My Ref: 2015/ENQ/00716
Your Ref:
Date: 03/11/2015
Enquiries to: James Hyde
Direct Dial: 01226 772683
E-Mail: jameshyde@barnsley.gov.uk

Description: Discharge of conditions 3, 4, 5, 6, 9 & 10 of application 2014/0938 (Demolition of existing dwelling and erection of 2 no. detached dwellings with integral garages).

Location: Land at 31 Tankersley Lane, Hoyland Common, Barnsley, S74 0PB

DRAWING No 788-03 REV

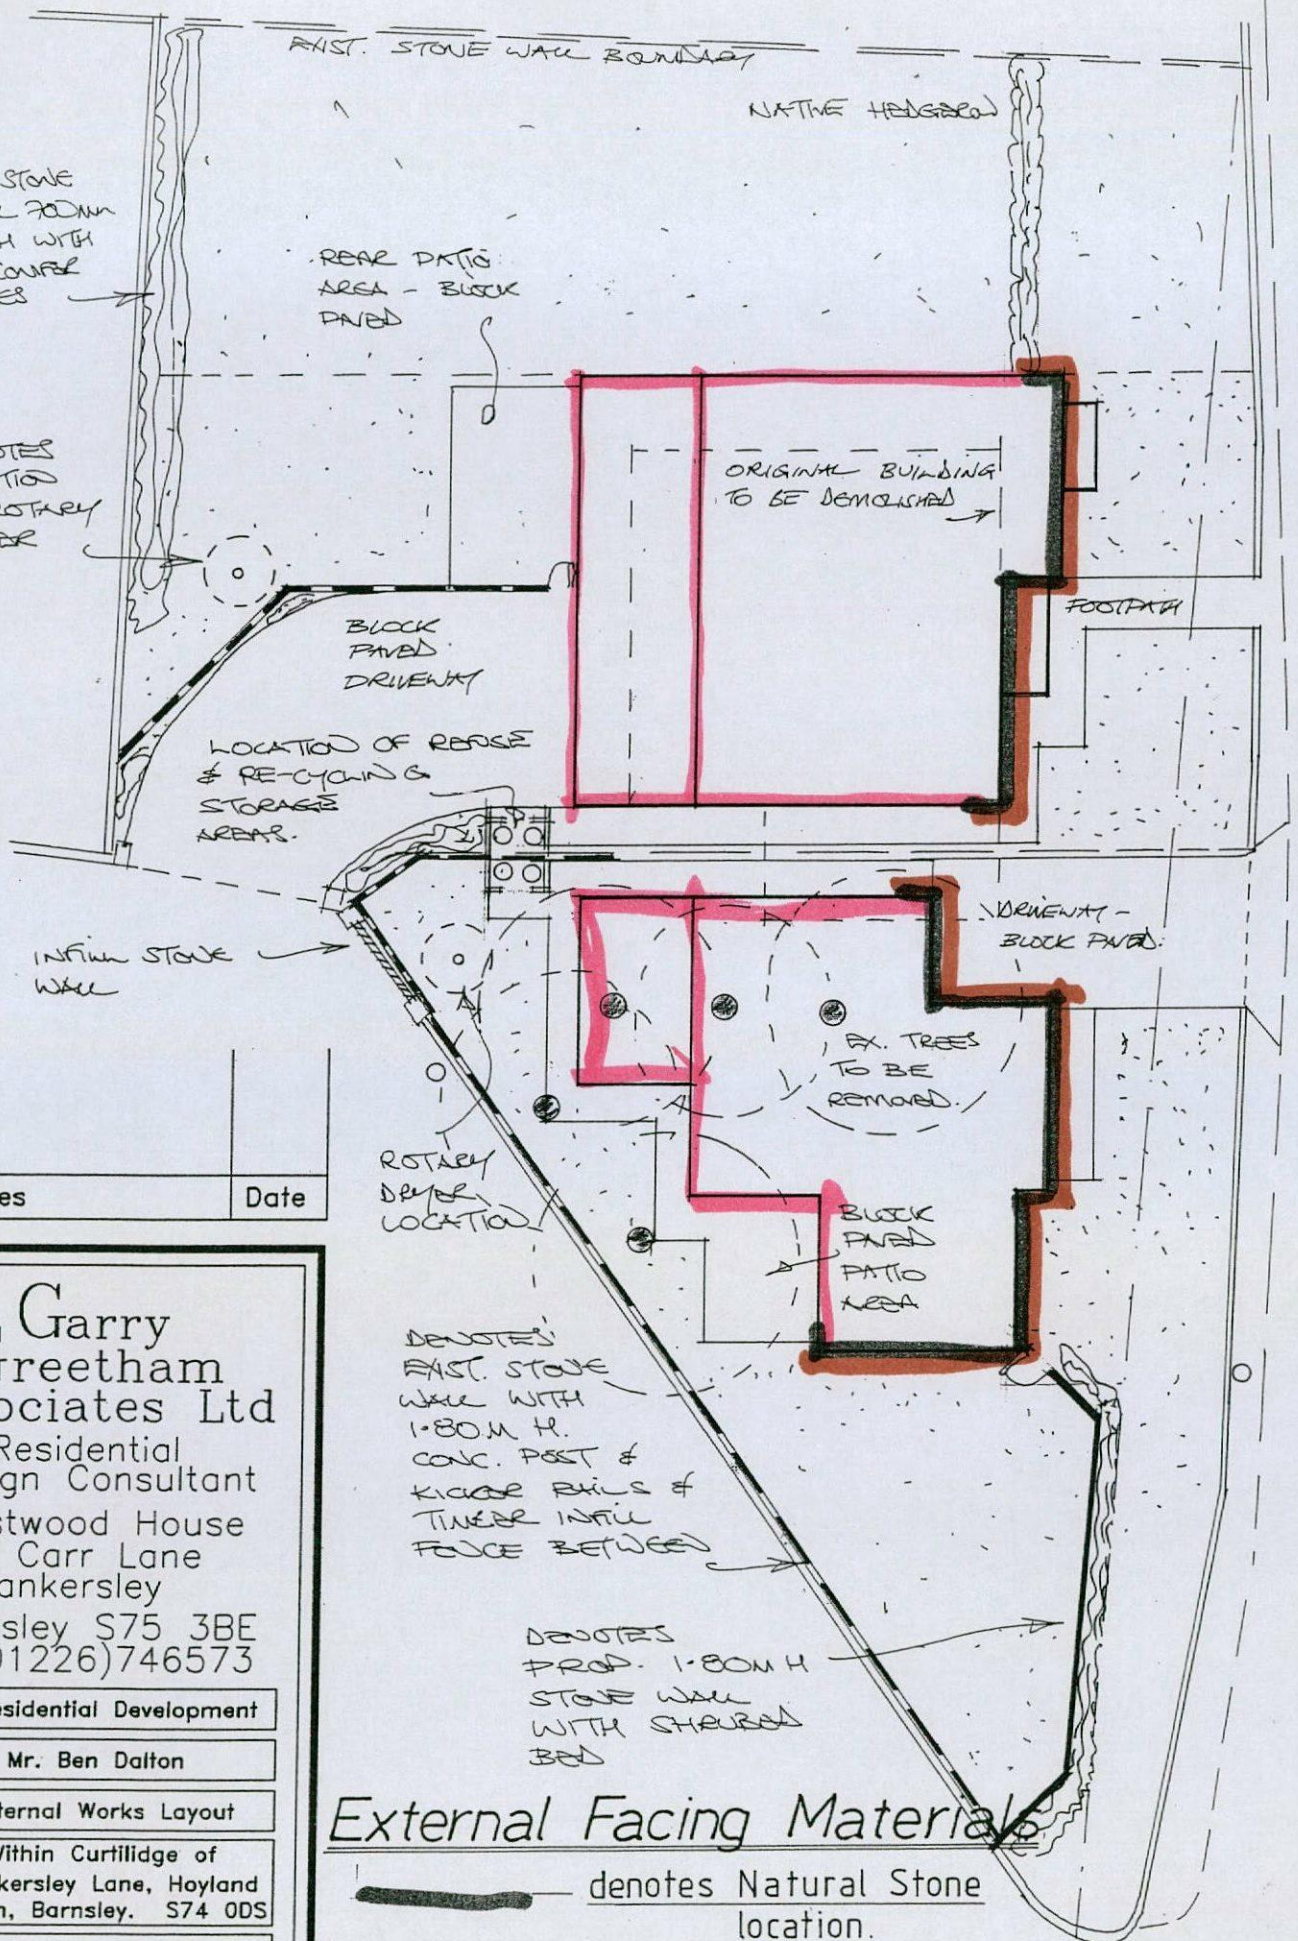
The levels shown on drawings 788-02-A and 788-03 are considered acceptable. The development shall proceed in accordance with the approved details.

The boundary treatments shown on drawing 788-03 'External Works Layout' are considered acceptable. The boundary treatment shall be completed before the dwelling is occupied. Development shall be carried out in accordance with the approved details and shall thereafter be retained.

PROJECT Residential Development
CLIENT Mr. Ben Dalton
TITLE Drainage Layout
ADDRESS Within Curtilage of
31 Tankersley Lane, Hoyland
Common, Barnsley. S74 0DS
DRAWN BY 999
SCALE 1:200 DATE Mar 14
DRAWING No 788-02 REV
Member of the Chartered Institute of Architectural Technologists

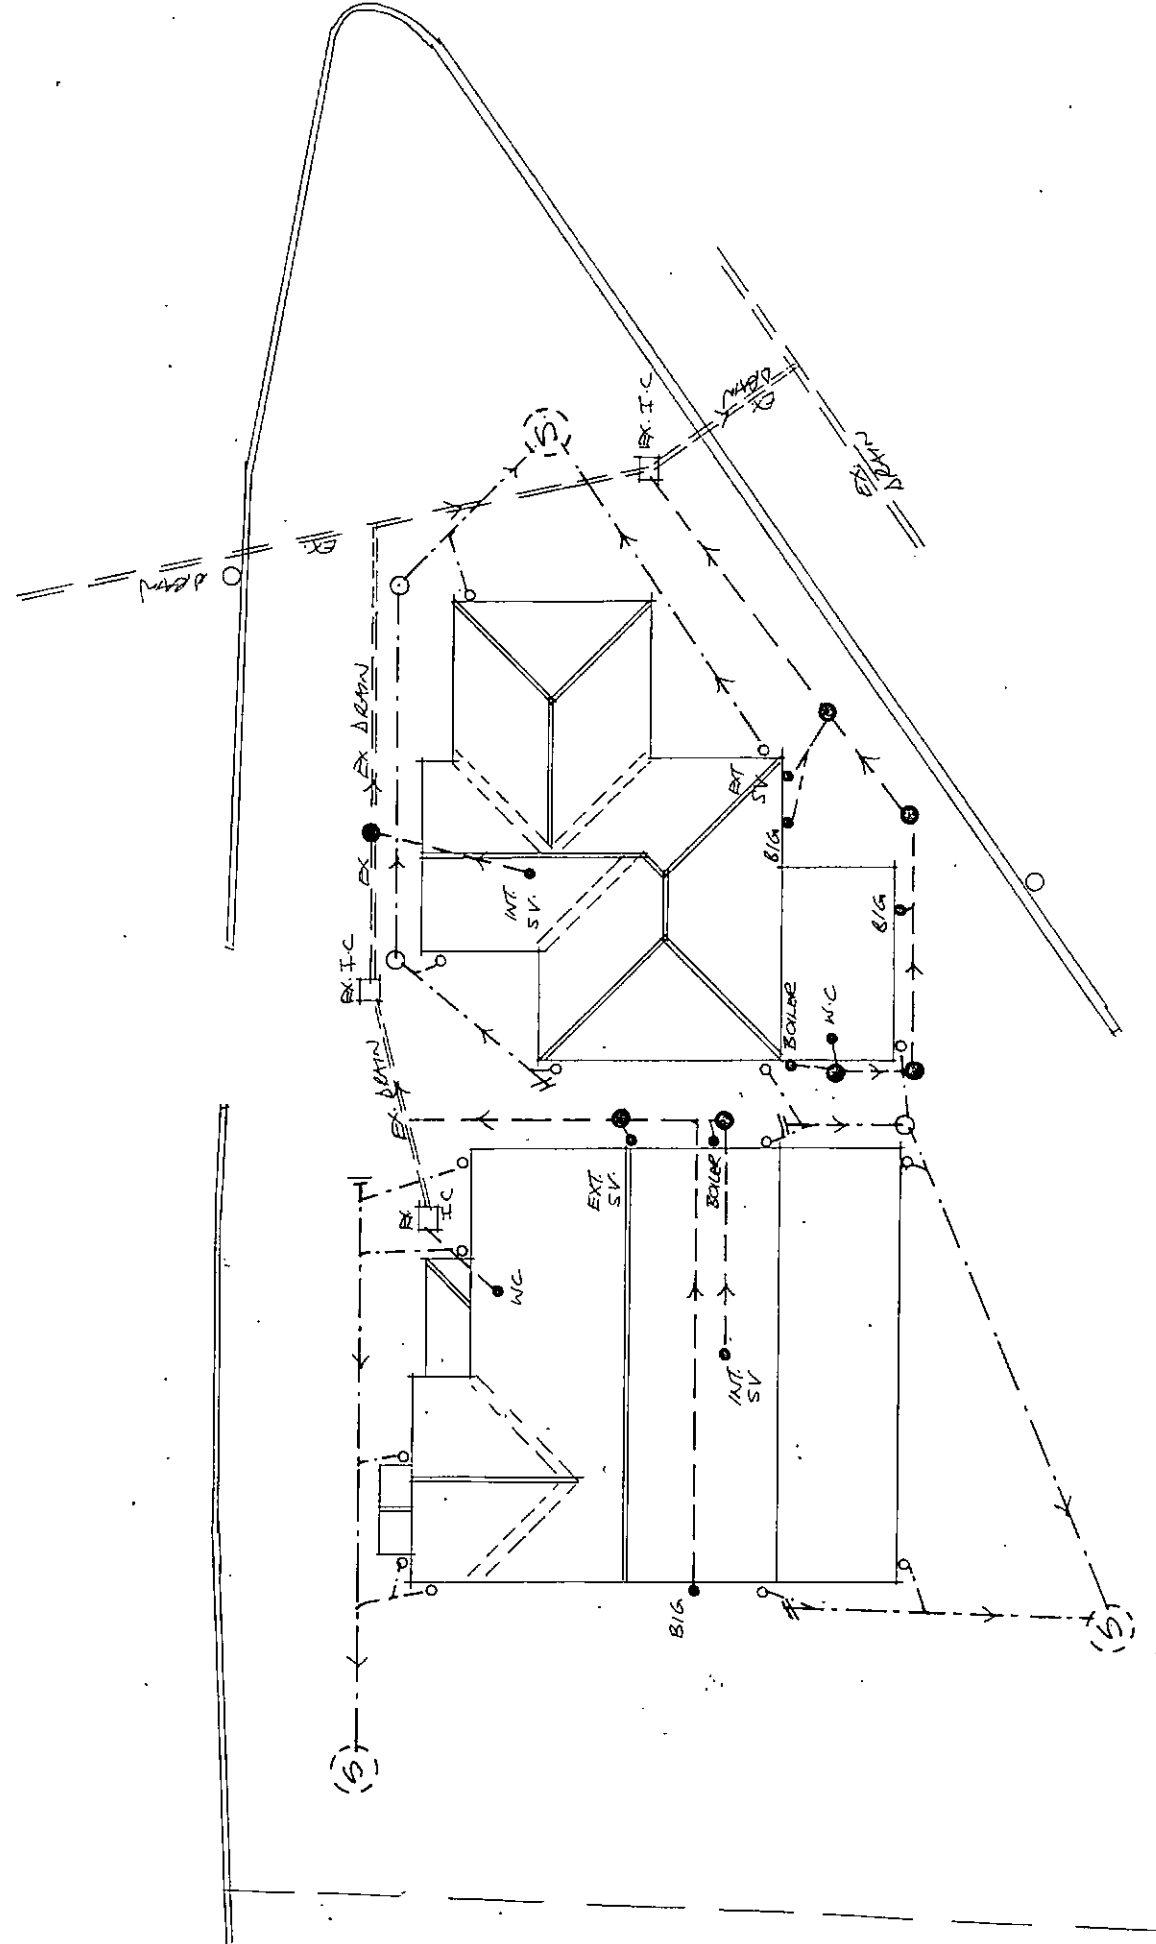
The drainage details shown on drawing 788-02-A 'Drainage Layout' have been checked and approved by the Councils Drainage Officer. No part of the development shall be occupied or brought into use until the approved scheme has been fully implemented and the scheme shall be retained throughout the life of the development.
